TR020002: Manston Airport

Application review

This document consolidates the Planning Inspectorate's observations and advice to RiverOak Strategic Partners (RSP) in respect of the content of the following application documents submitted on 10 April 2018:

Habitats of Protected Species, Important Habitats or Other Diversity Features and Waterbodies in a River Basin Management Plans

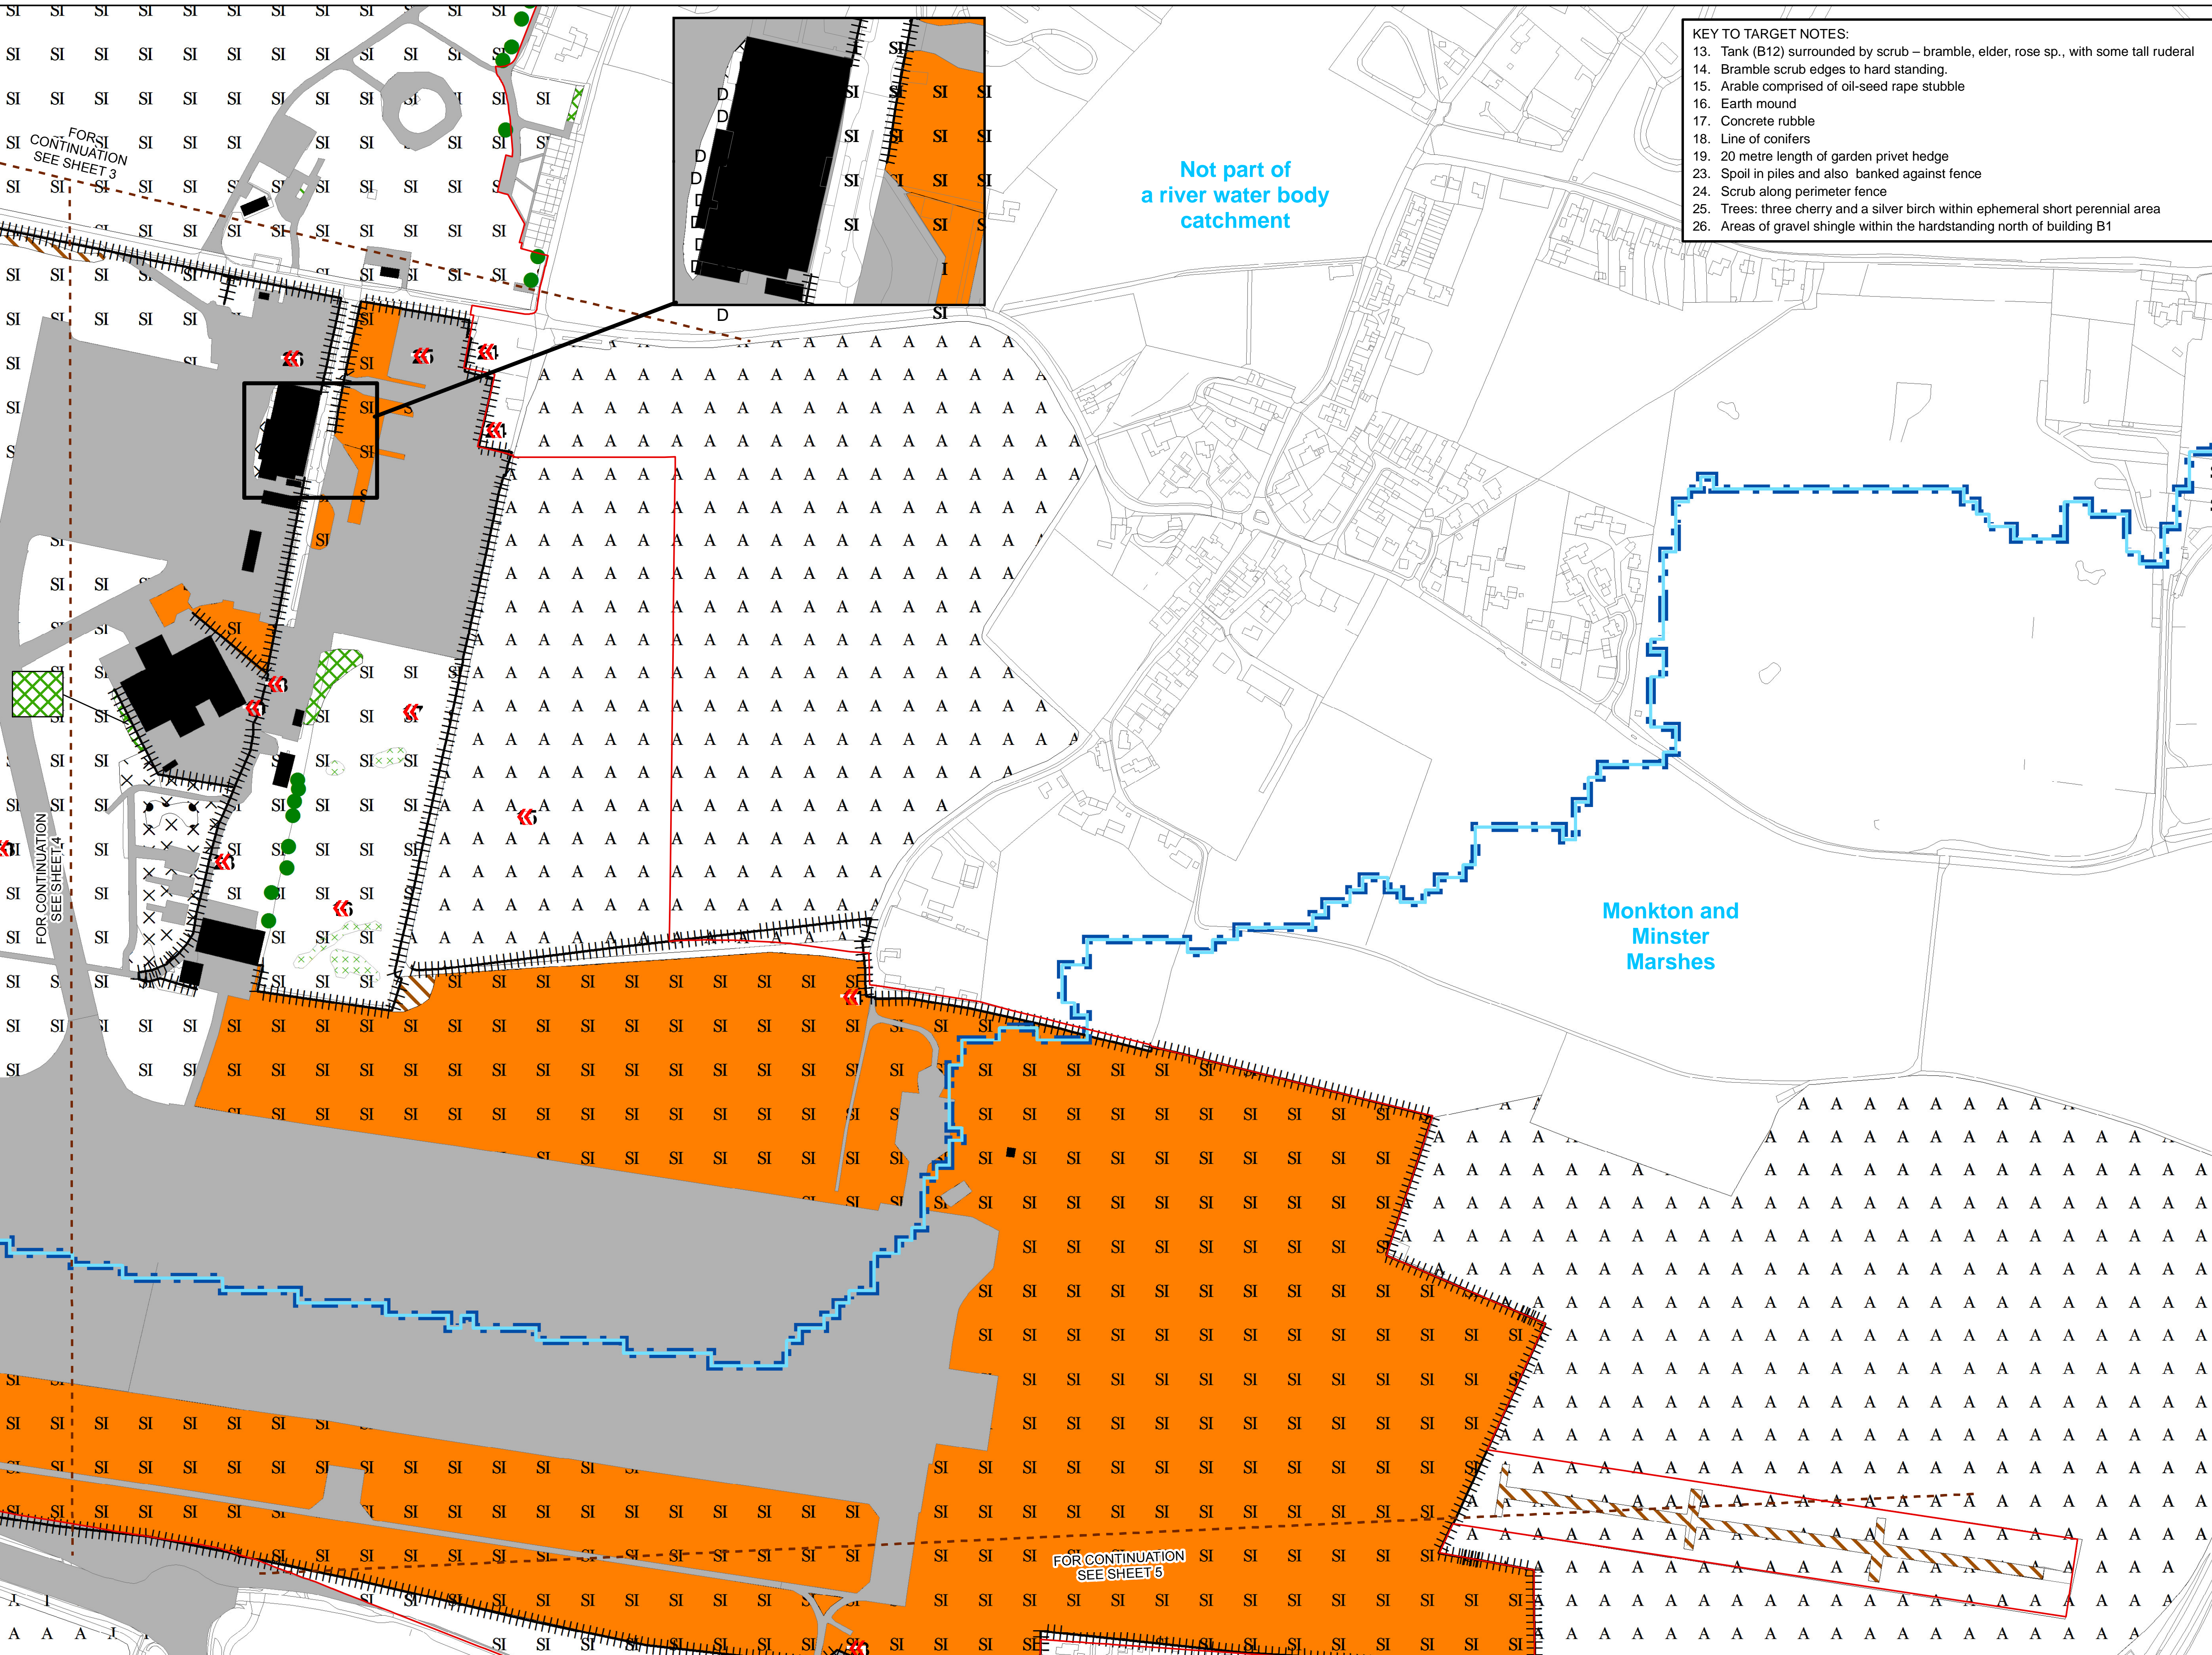
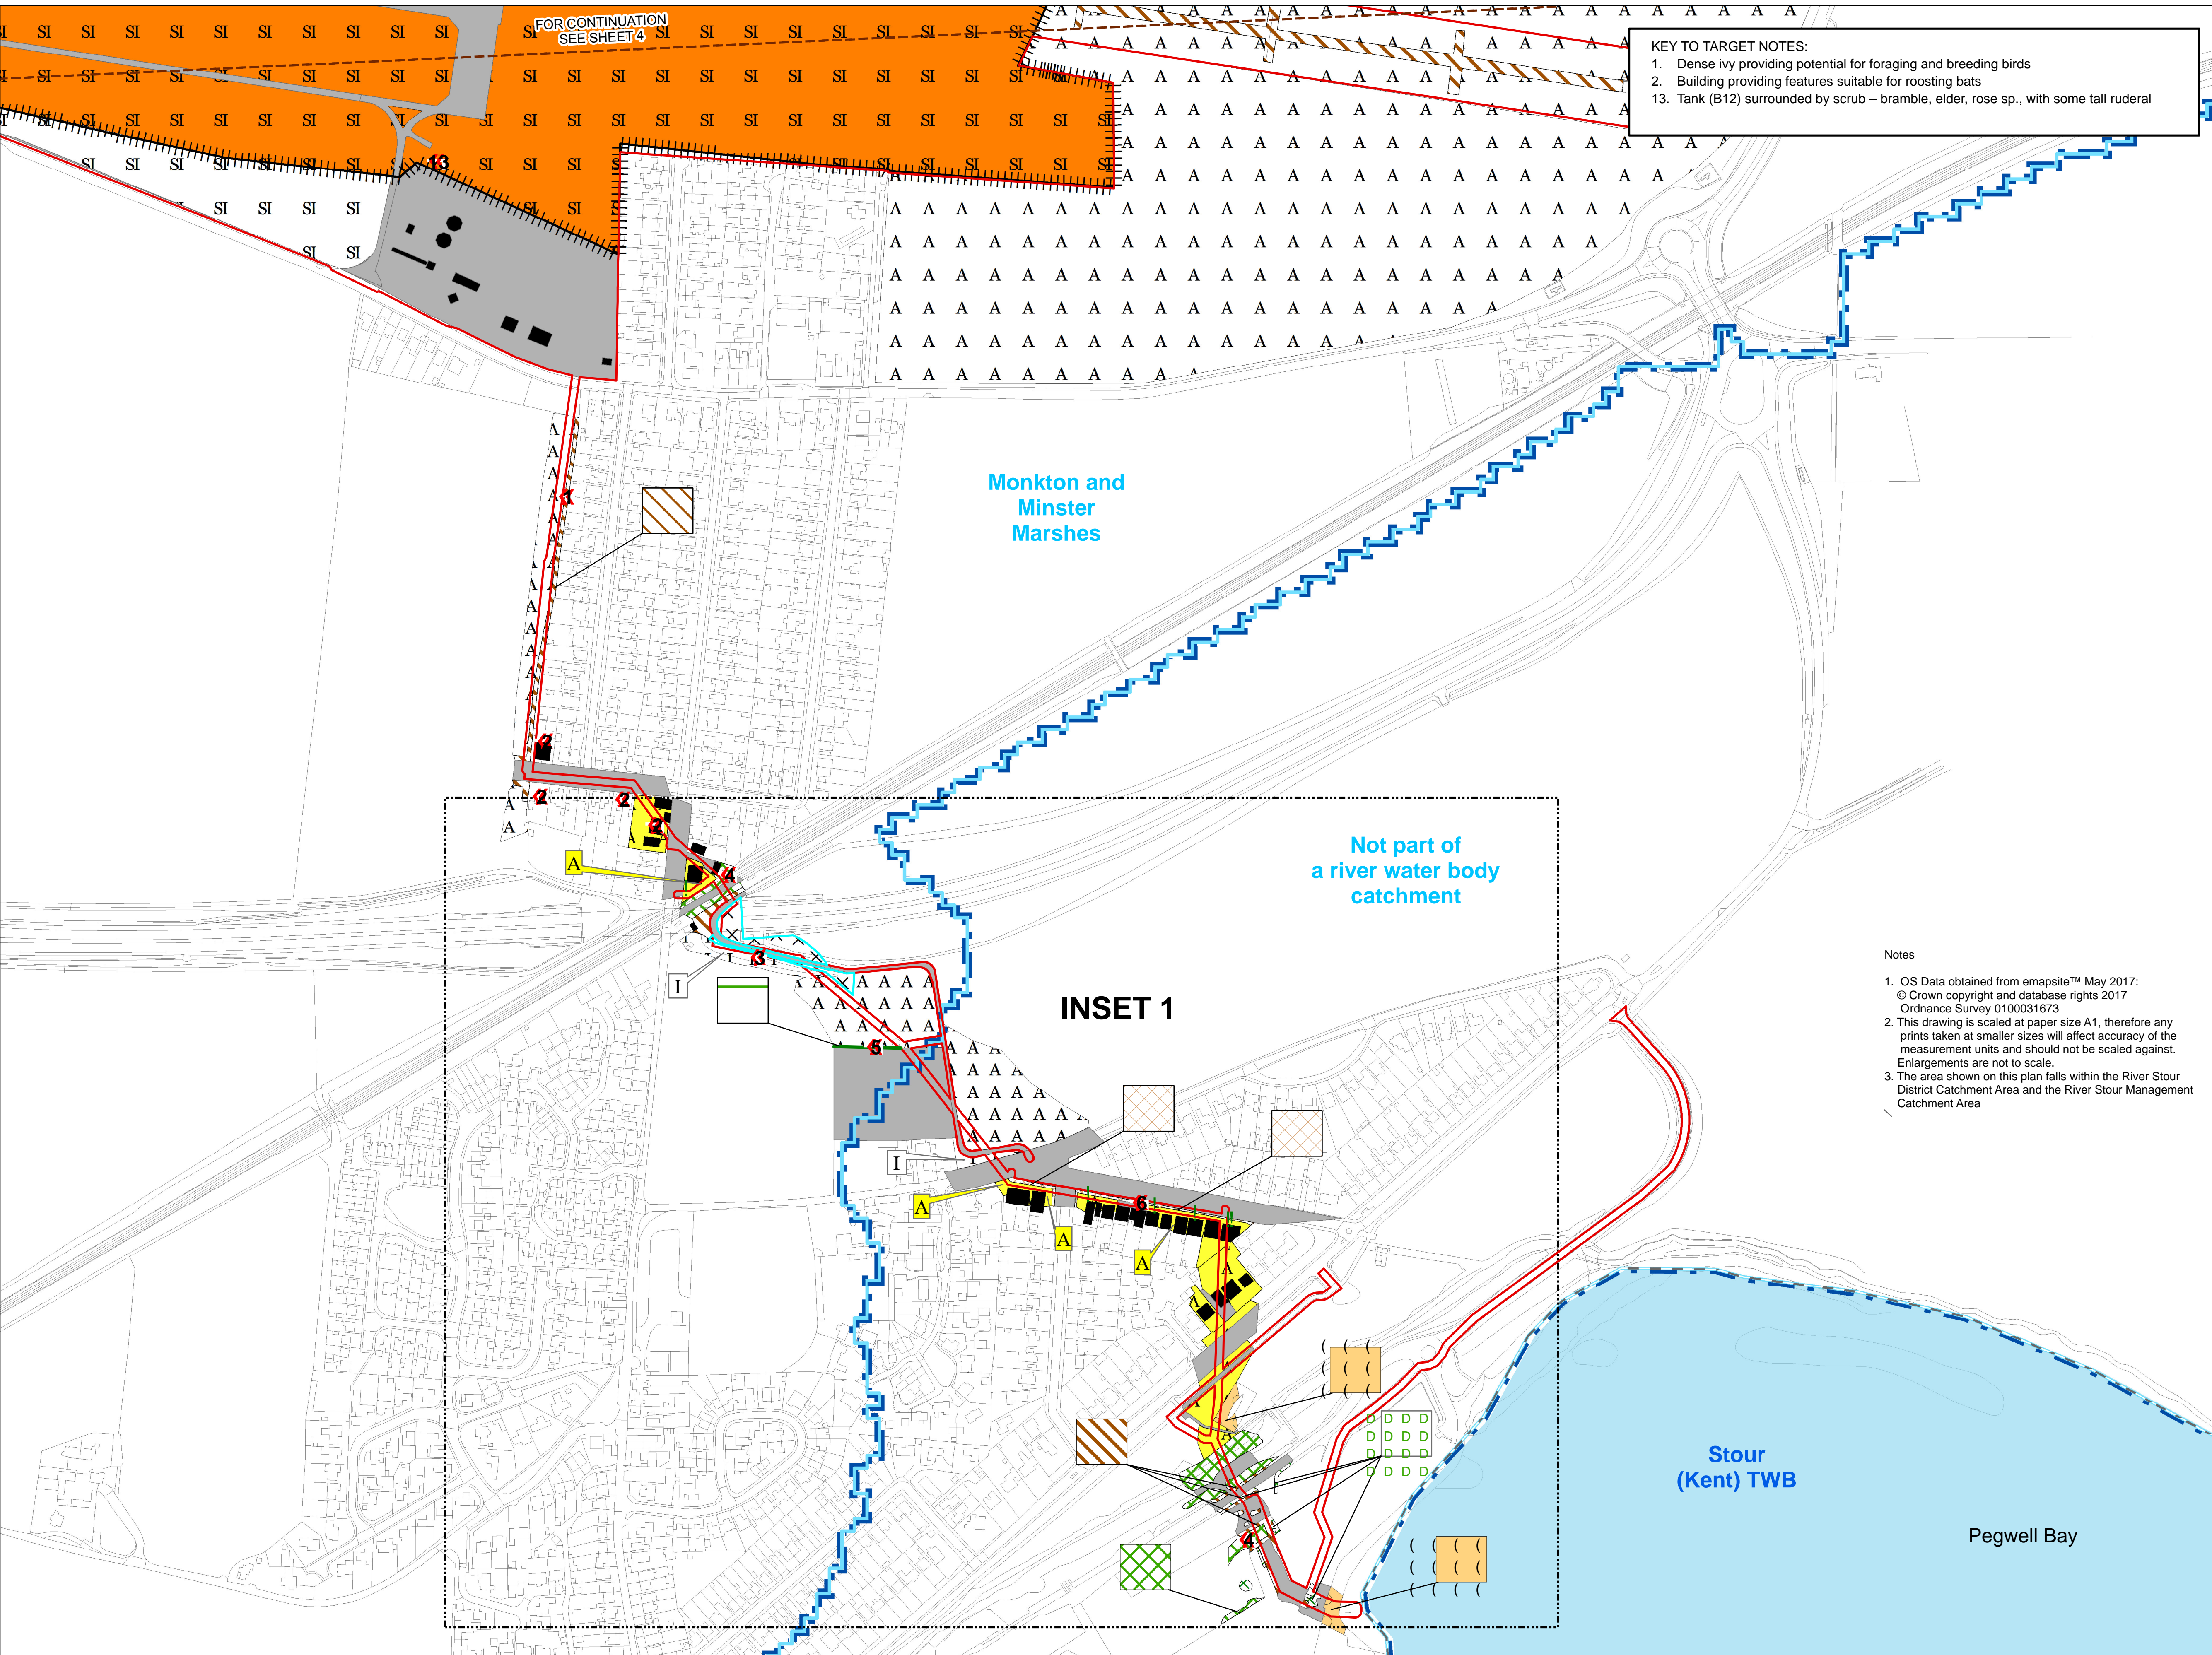
Revision number(s) were not stated on the Habitats of Protected Species Plans.
